# CITY OF ALBUQUERQUE

August 13, 2021

**RE: Cutler Right-of-Way Dedication  
Master Drainage Plan  
Engineer's Stamp Date: 07/15/21  
Hydrology File: H17D036**

MASTER DRAINAGE PLAN CUTLER R/W

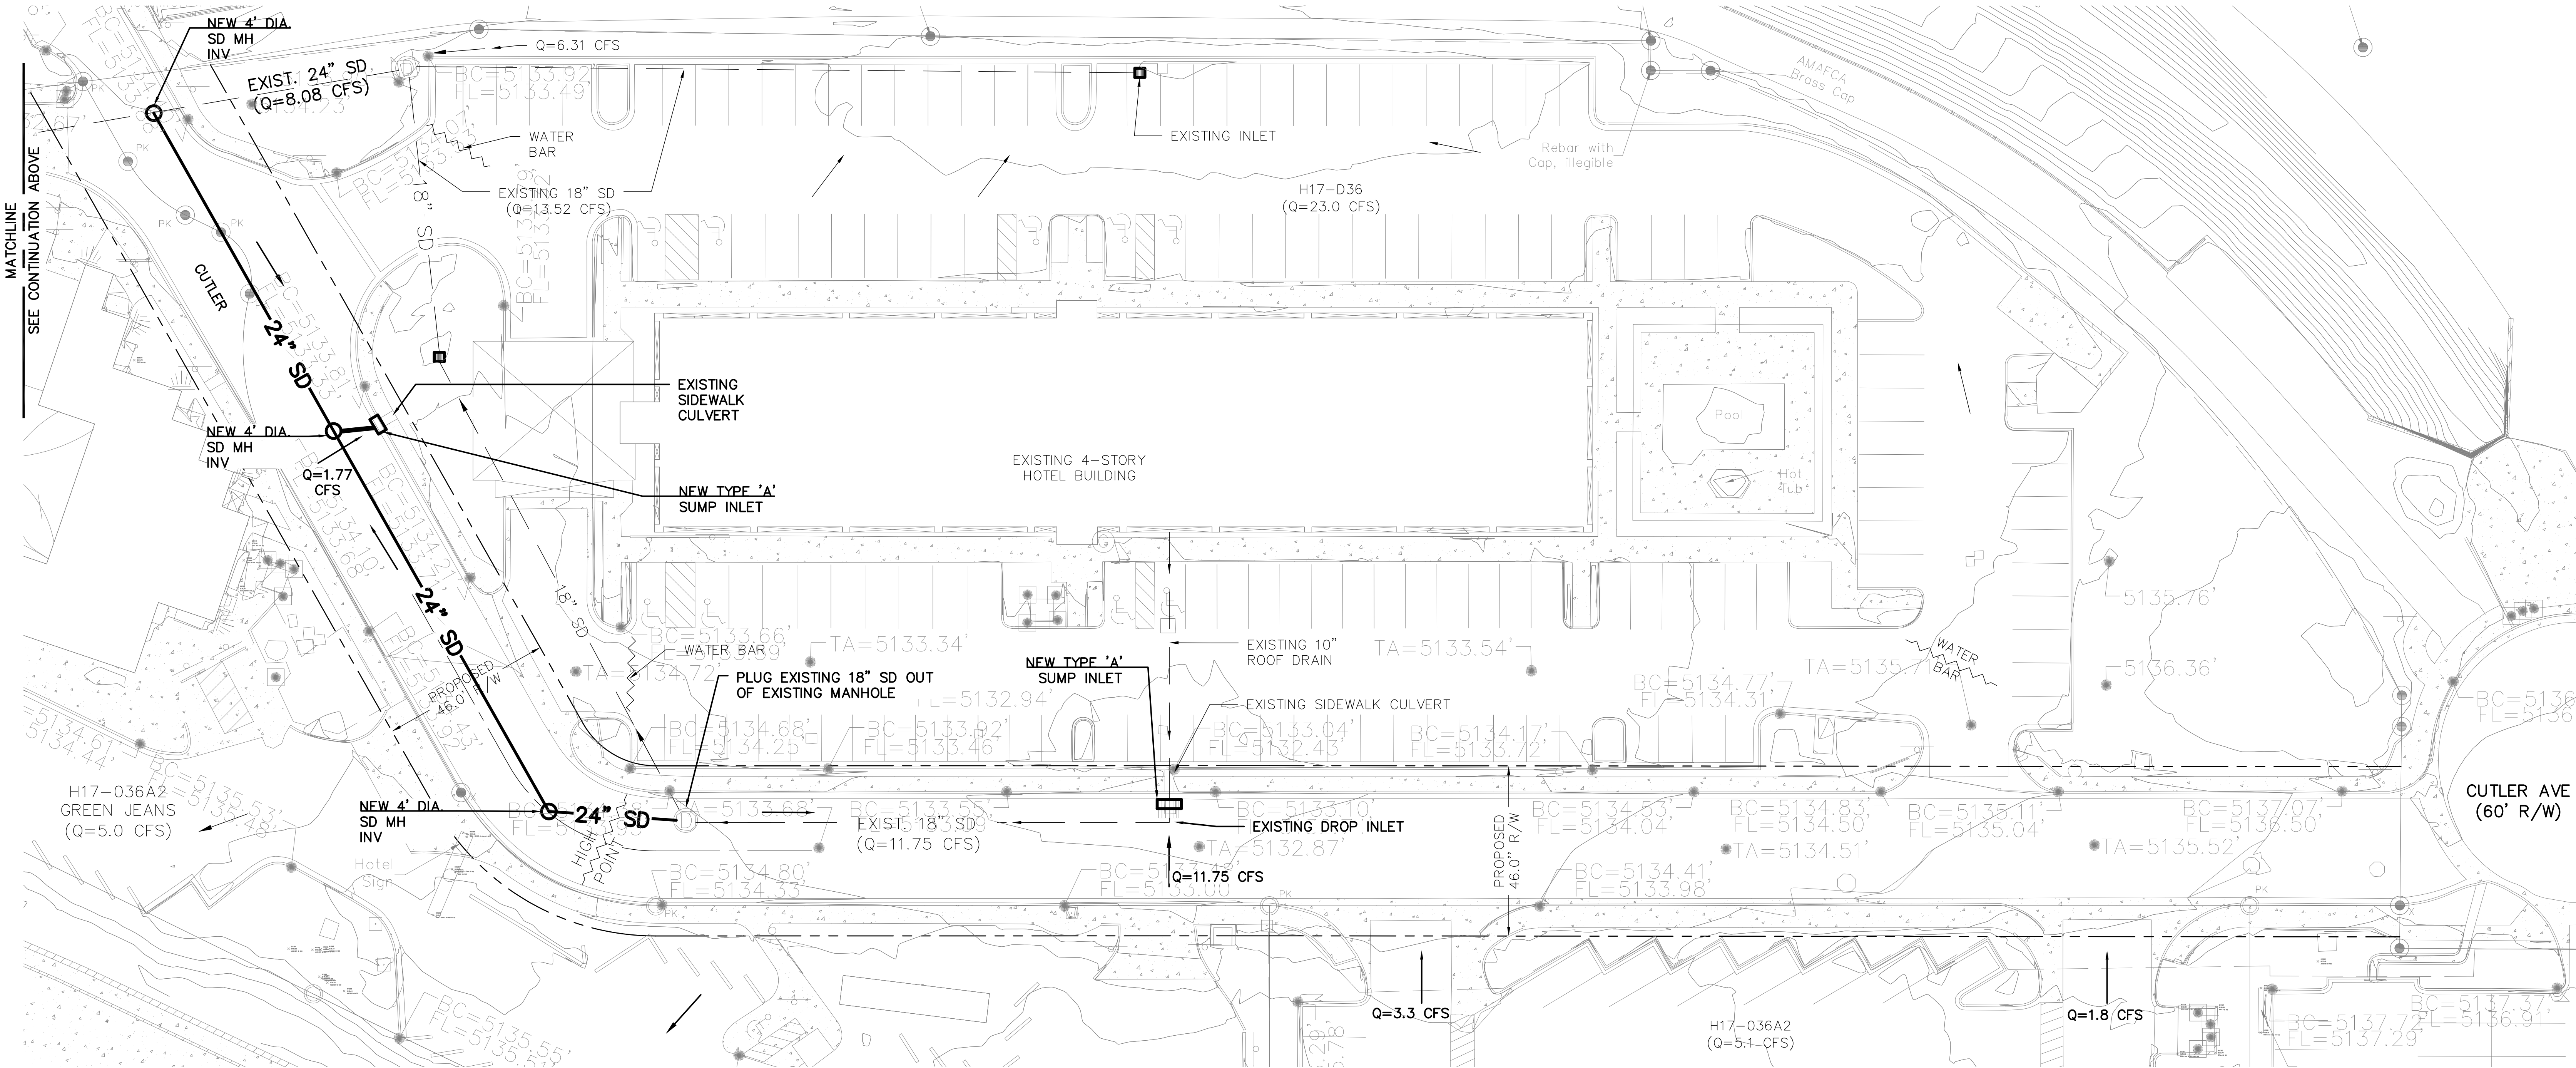
1. Please provide a Grading Plan with enough grades for the Work Order. (please see image below)

2. Please verify the pipe size, material of the existing storm sewer. Also please provide the rim elevation of the manholes, pipe inverts, inlet rim elevations. This will be needed to determine if these need to be replaced and added to the Infrastructure List., and get grate elevation.
3. Also please include any changes that will be done for the Work Order on the Grading Plan. For example, at the cul-de-sac the road will be flattened and straightened. (please see image below)

4. Question – Are the storm sewer going to be maintained by the City or by the private development?
5. Question – Are all drives going to be brought to City standards (COA Drawing 2425A)?
6. Question – Is the roadway staying as an elevated road? Is this road have a 2% max cross slope? Or is the roadway going to have a crown in the middle?
7. If the answer to #4 is that the City is going to maintain the storm sewer, Then I suggest that an inlet be installed at the sump on the west side of the project area and that a new pipe is installed along with a new manhole. Then the existing pipe on the Green Jeans property will have be placed in a Public Drainage Easement. (See image below)

8. Master Drainage Plan. Please show where the storm pipe connects to the DOT inlet and then discharges into the Embudo Channel.
